Your Ref 23/01151/APP

6th November 2023

PROPOSED NON-MATERIAL AMENDMENT TO PLANNING PERMISSION REF. 23/01151/APP AT HMP SPRINGHILL, EDGOTT, AYLESBURY

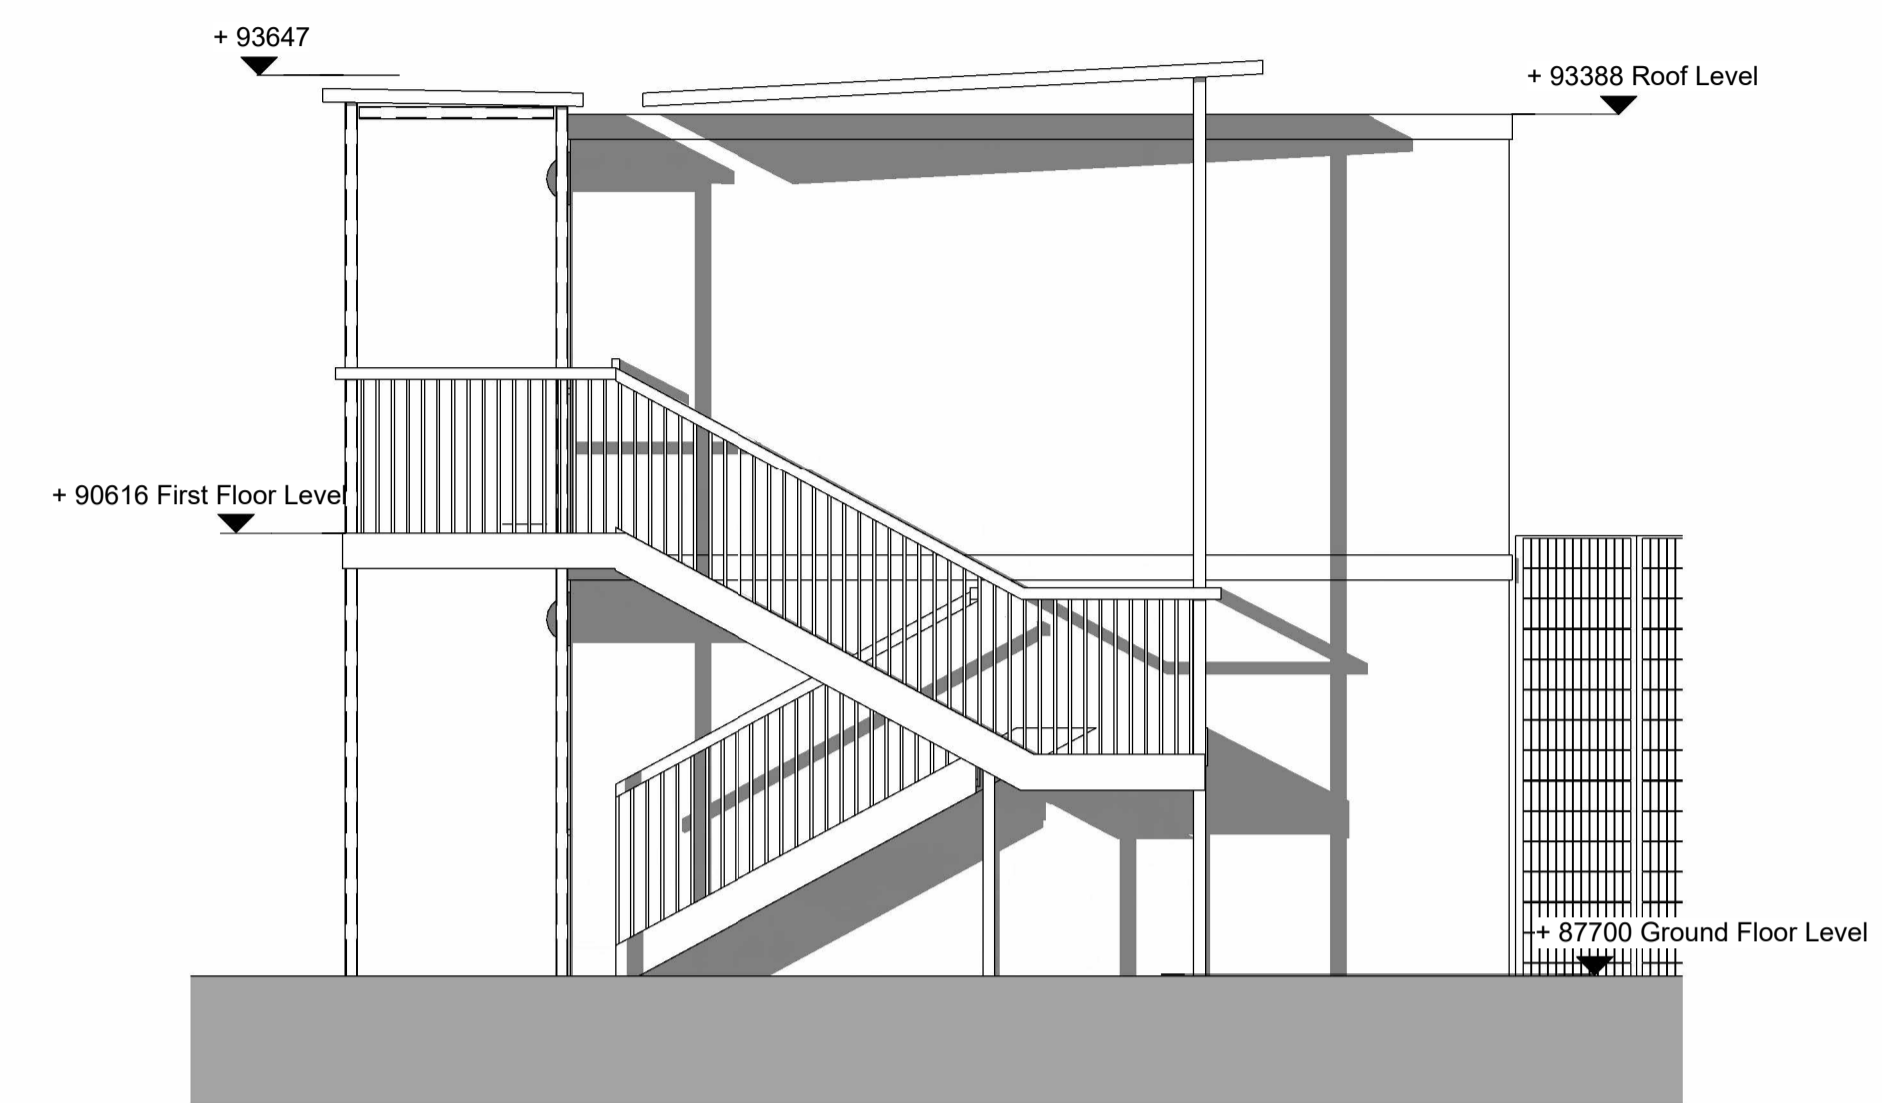
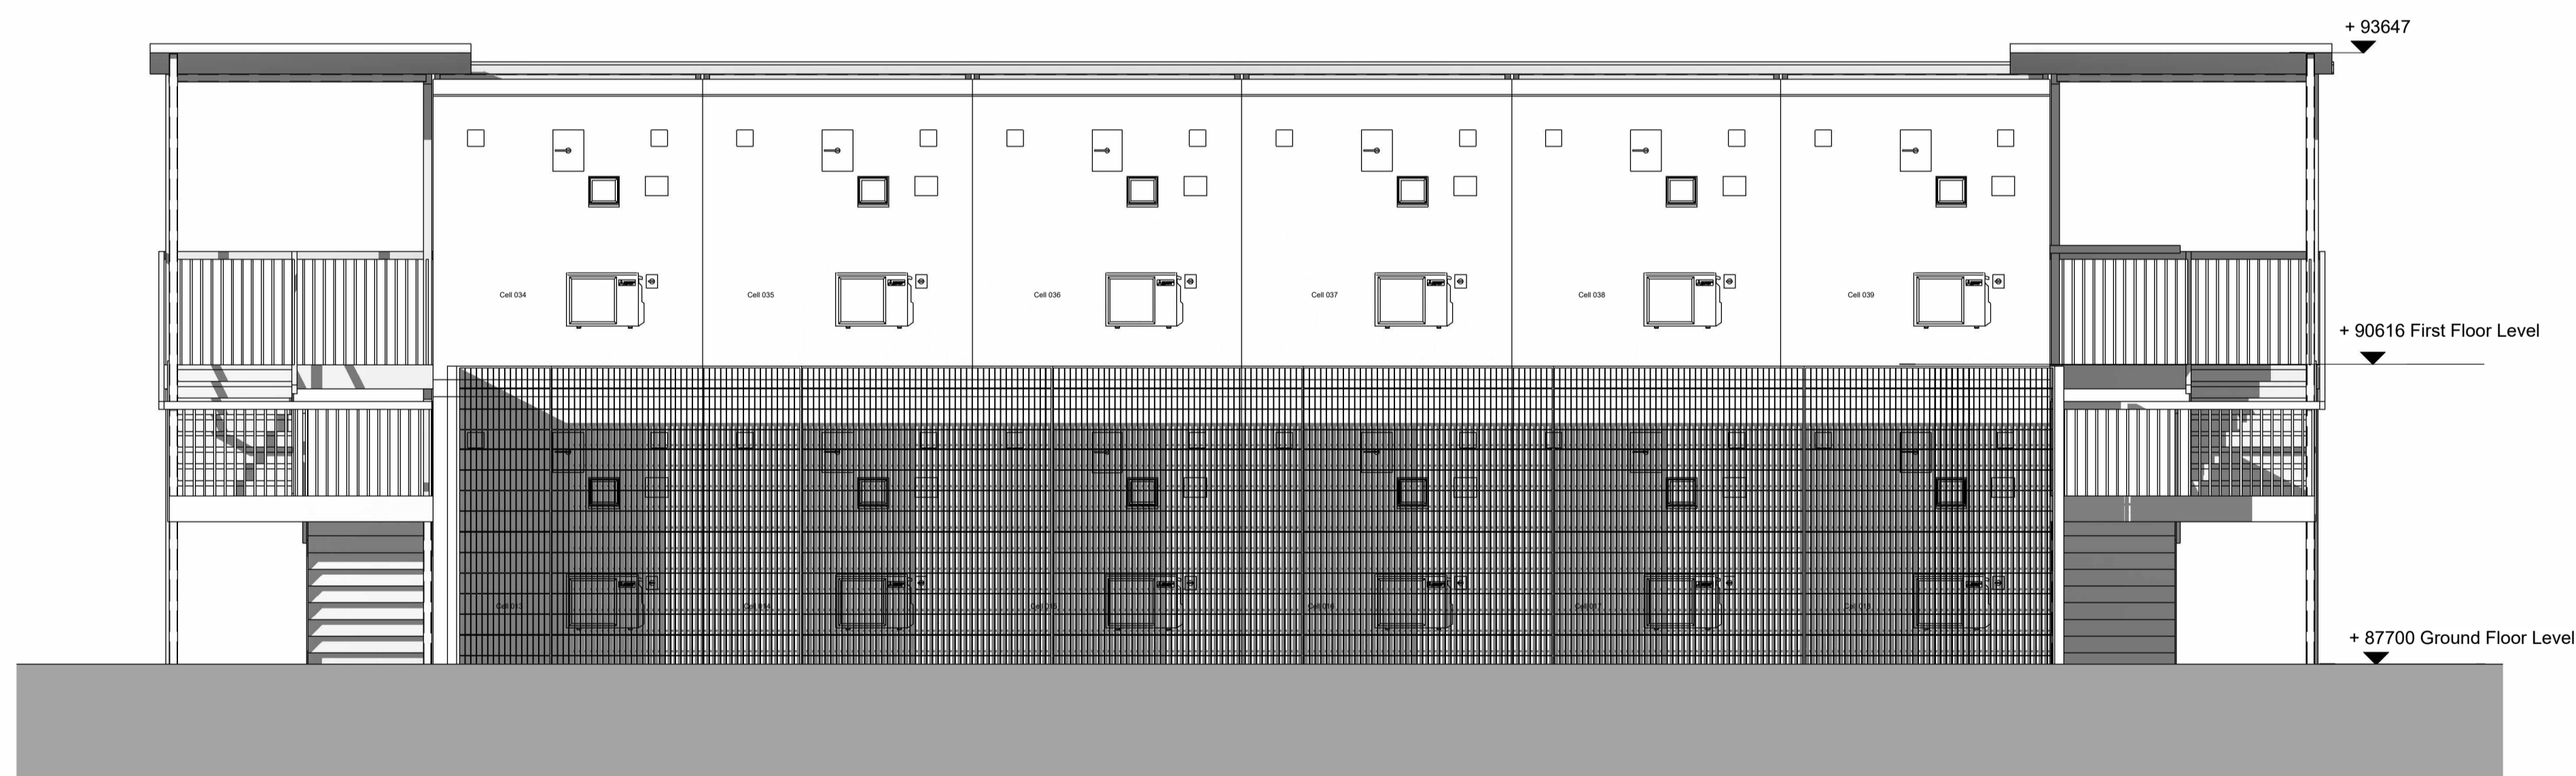
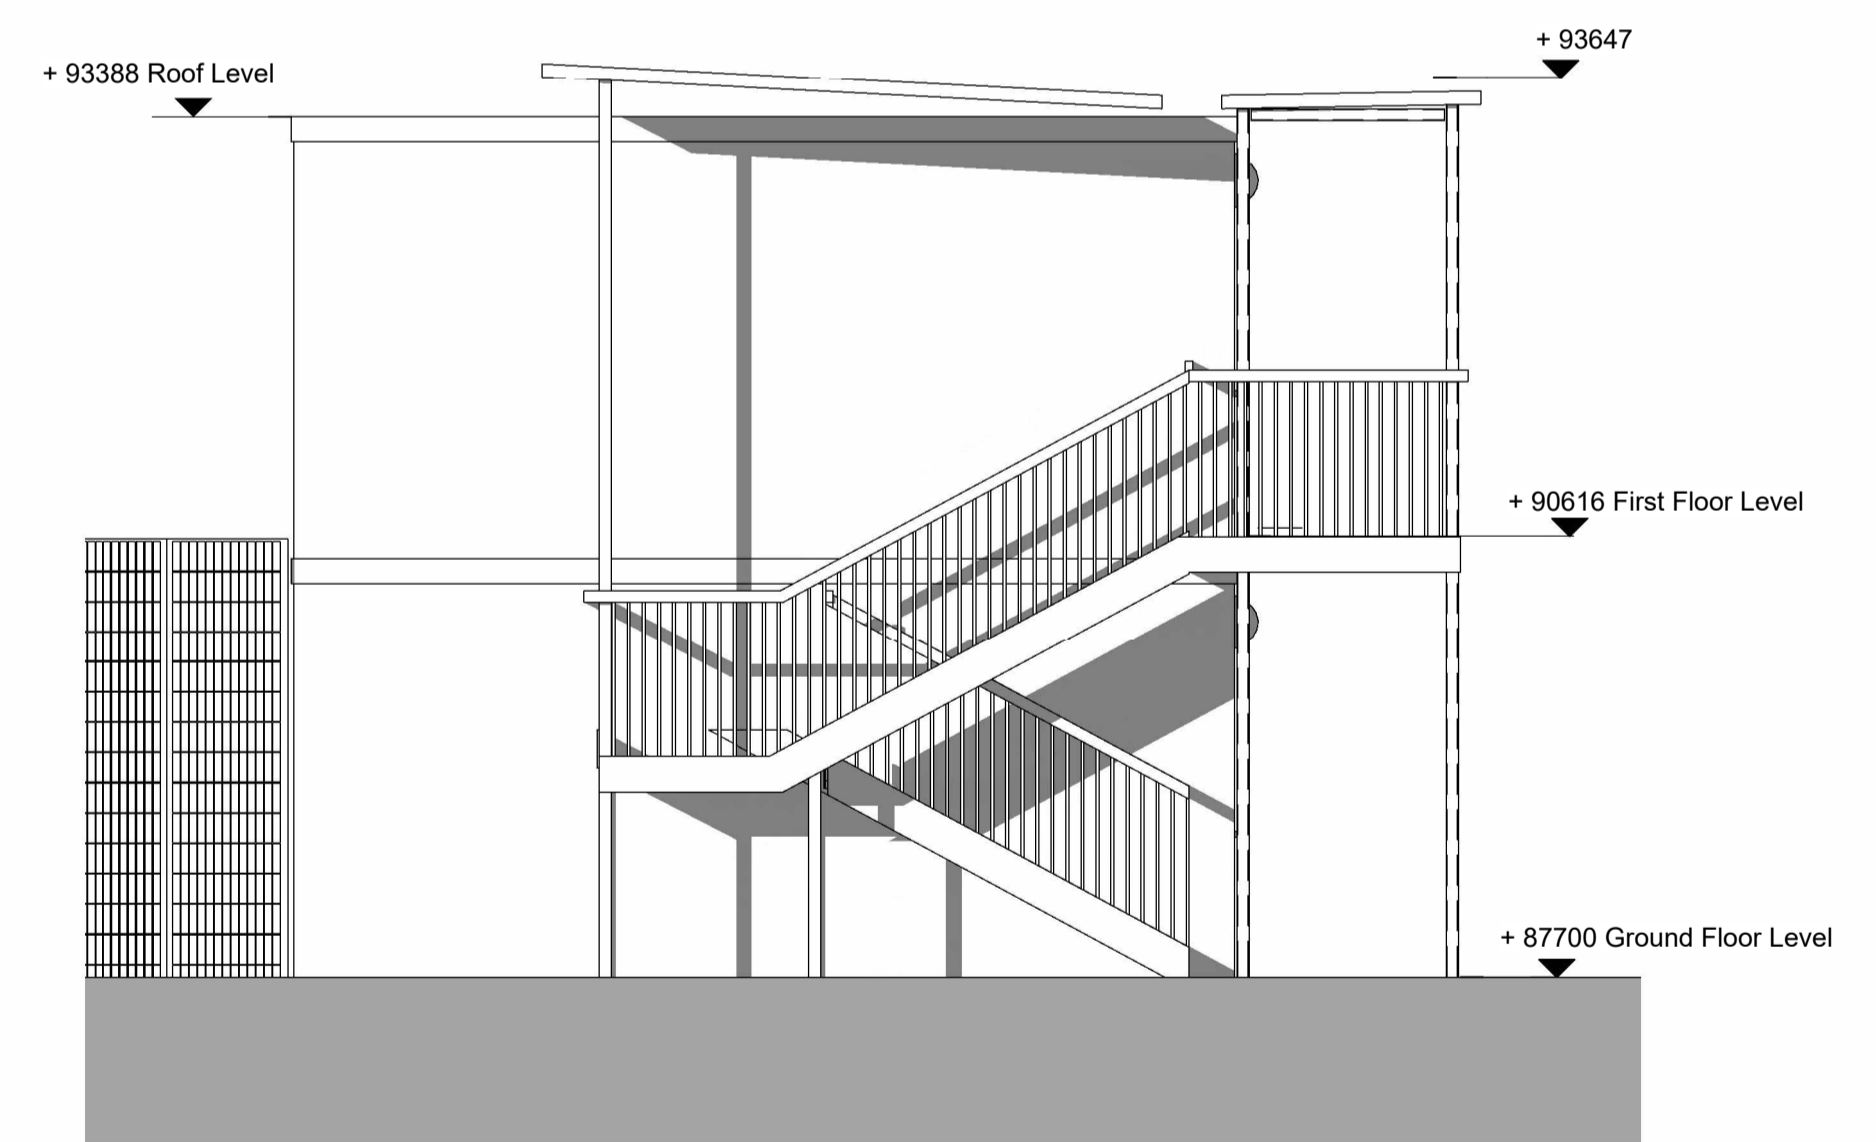
Block 3 has been moved to the east by 2 meters.

Walls near the workshop to the north of block 3 are to be demolished.

Covers to be added over the stairs.

Block 3 Proposed Elevations – Rev C (ref: 441830-HLN-ZZ-DR-A-P010)
